RE: PLANNING APPLICATION 2019/1265 - INVANS

APPLICATION NO: 2019/1265/INVALID
DESCRIPTION: Erection of detached garage
LOCATION: 32 Honeywell Place, Barnsley, S71 1QB

PLAN (1:50)

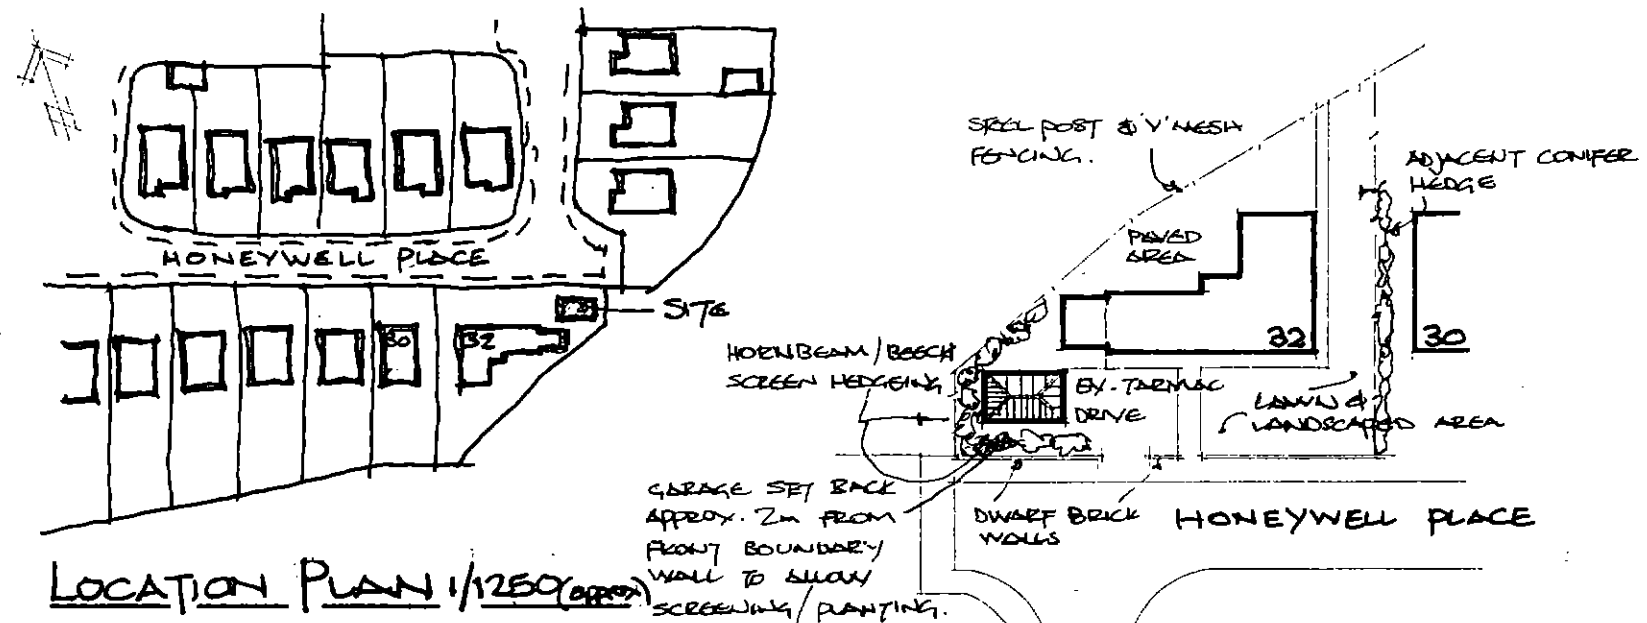
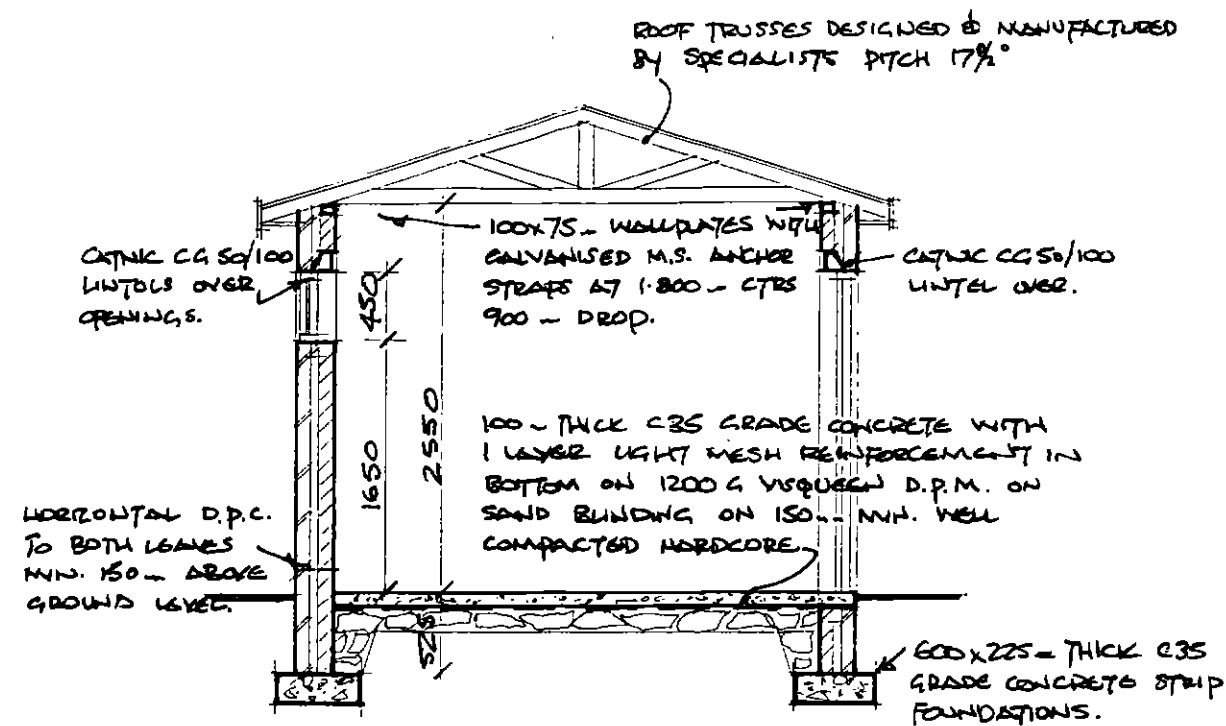
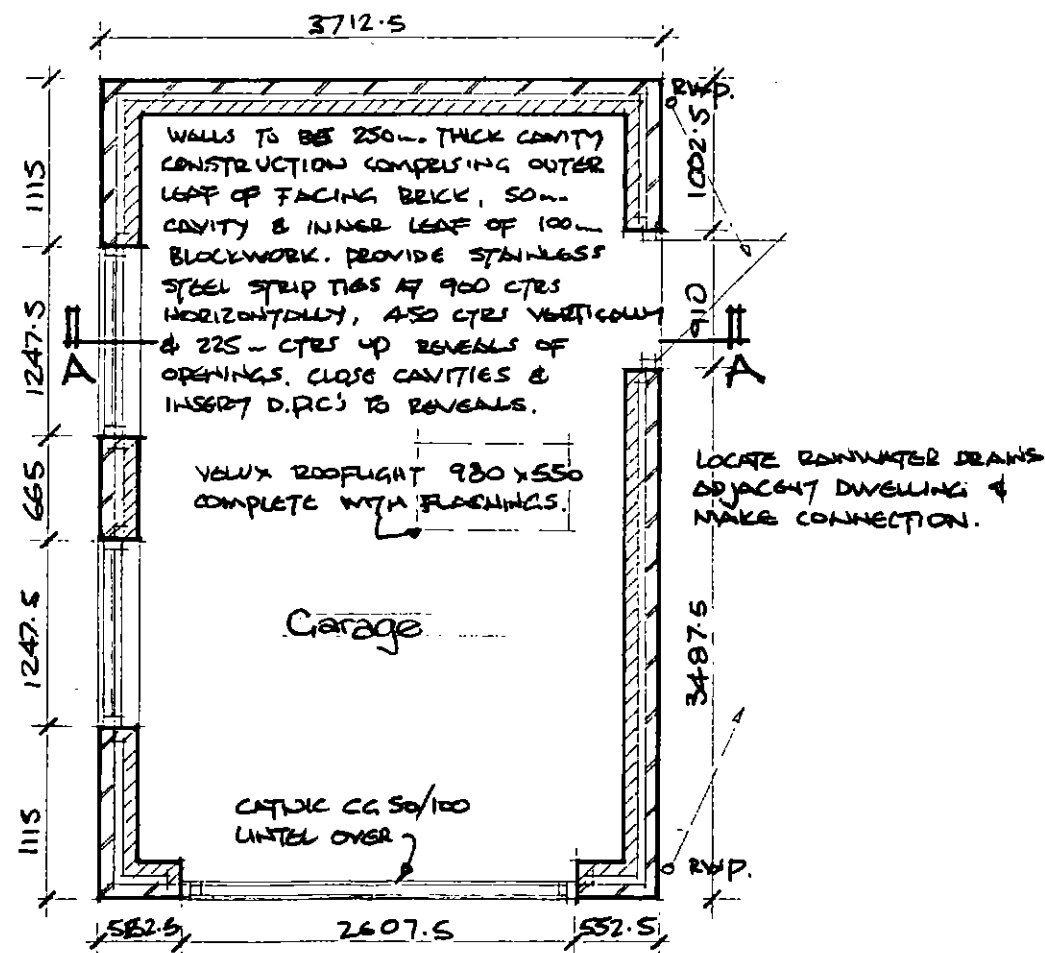
- **The gates and fencing requires planning permission by virtue of their location abutting a highway and their height being above 1m. Are you happy for those to be included in the application and if so please can we have some annotations confirming the actual heights.**

I CAN CONFIRM THAT I AM HAPPY FOR THE GATES & FENCING TO BE
INCLUDED IN THE APPLICATION AND ENCLOSE & LINE DRAWING
CONFIRMING DIMENSIONS.

ALL MEASUREMENTS TAKEN FROM EXISTING FOOTPATH LEVEL
 VARYING HEIGHTS USED FOR AESTHETICS TO FOLLOW NATURAL SLOPE OF FOOTPATH
